LIFT STATION #1 REPLACEMENT

***SITE DEVELOPMENT PLAN
DRAINAGE LETTER***

**RE: Woodmen Hills Metropolitan District
Lift Station #1 Replacement
Administrative Plot Plan – Drainage Letter
Address: TBD (Current Site Address: 12048 Falcon Highway, Peyton, CO 80831)**

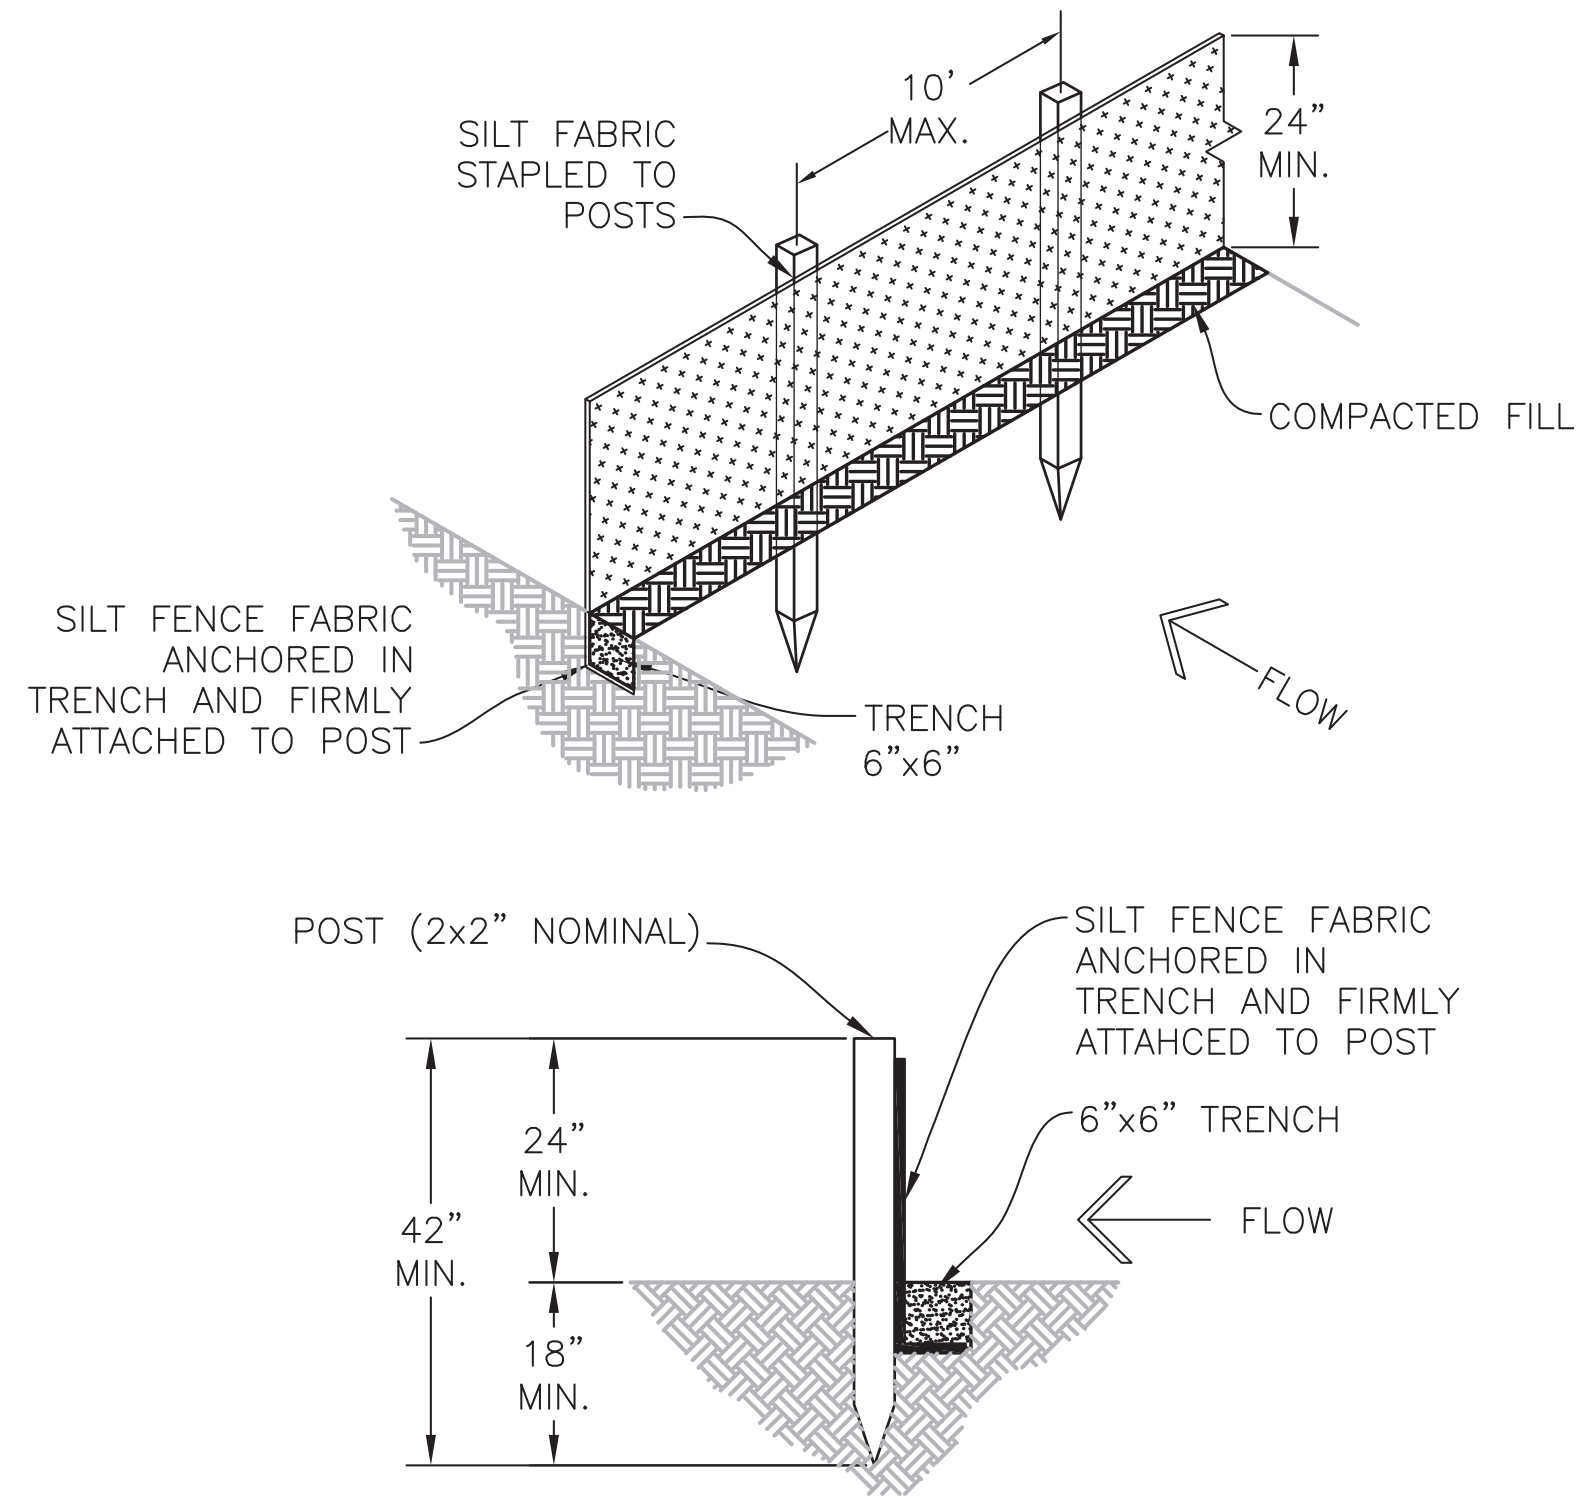
Move this sheet after the coversheet.

Move this sheet after the coversheet.

**C** PERMEABLE PAVER - PLAN  
SCALE: N.T.S.

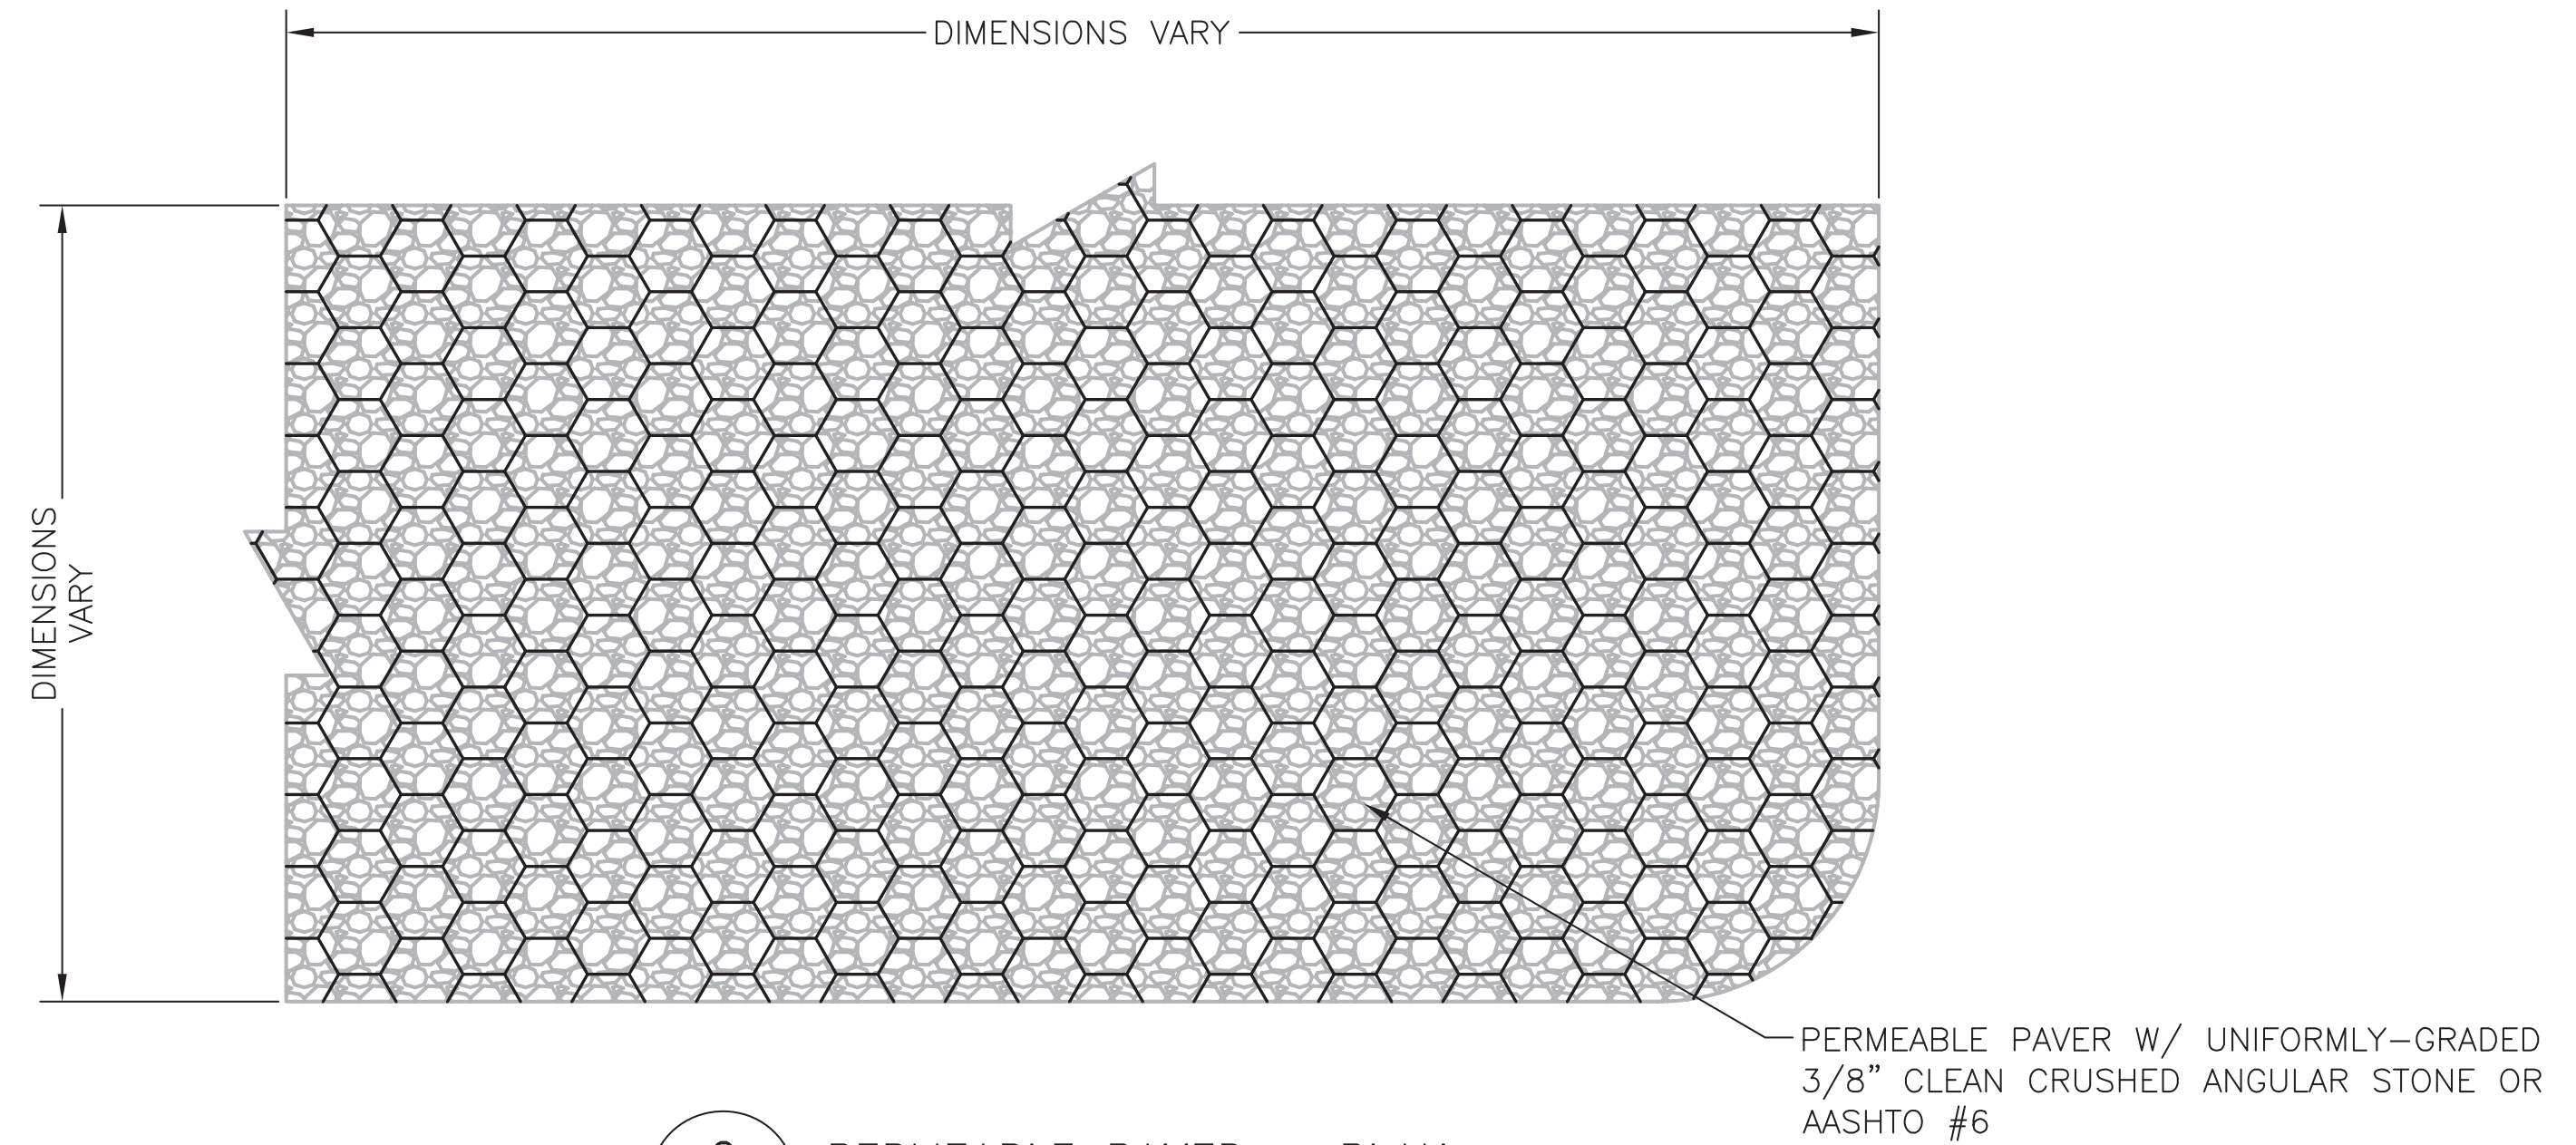
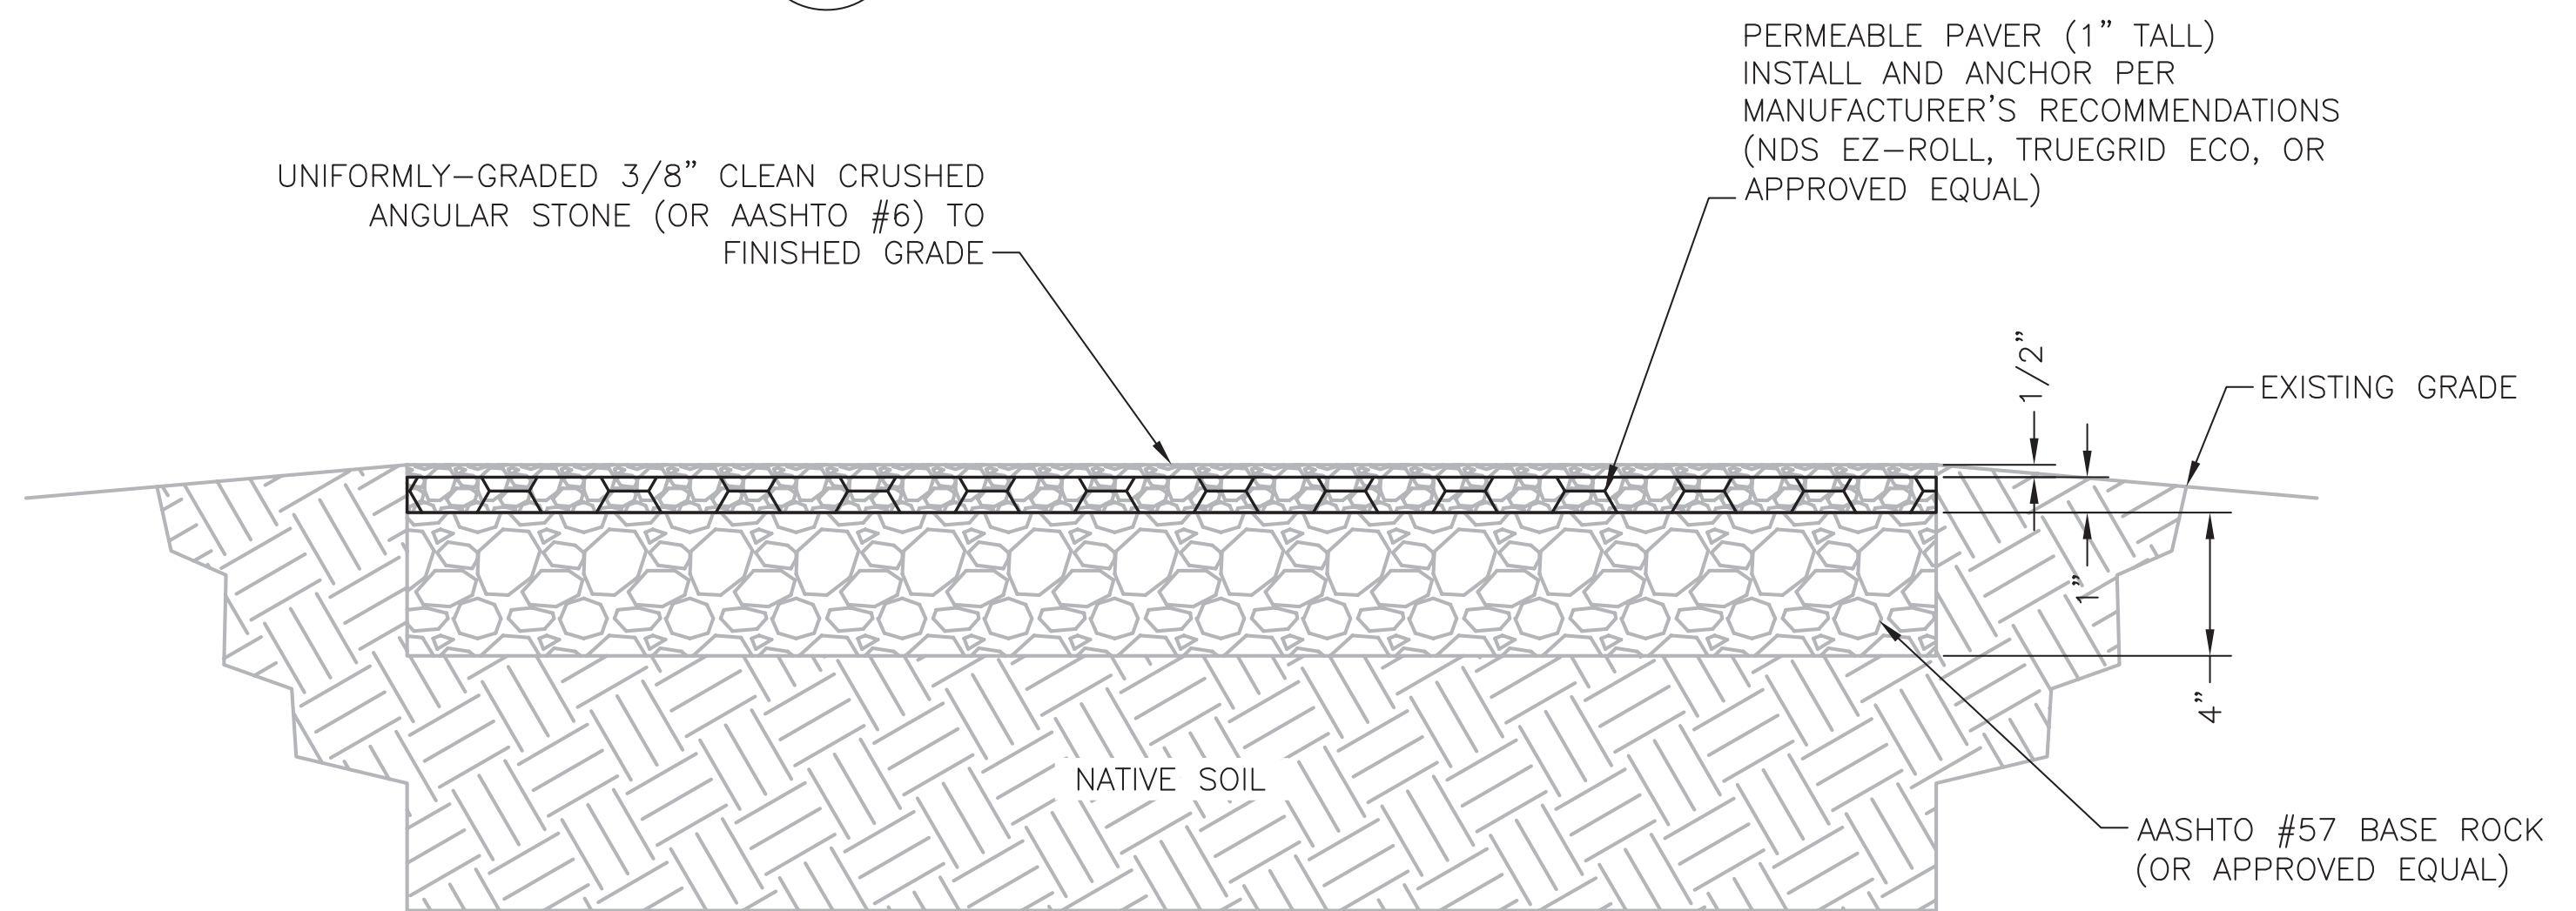
Follow the calculation of the WQCV and
Volume as outlined in UDFCD Volume 3
Chapter 3 (Calculation of the WQCV) and
Chapter 4 Permeable Pavement Systems
fact sheet. The fact sheet provides the
procedure for calculating the storage
volume. Include calculations as an
appendix.
<https://udfcd.org/volume-three>
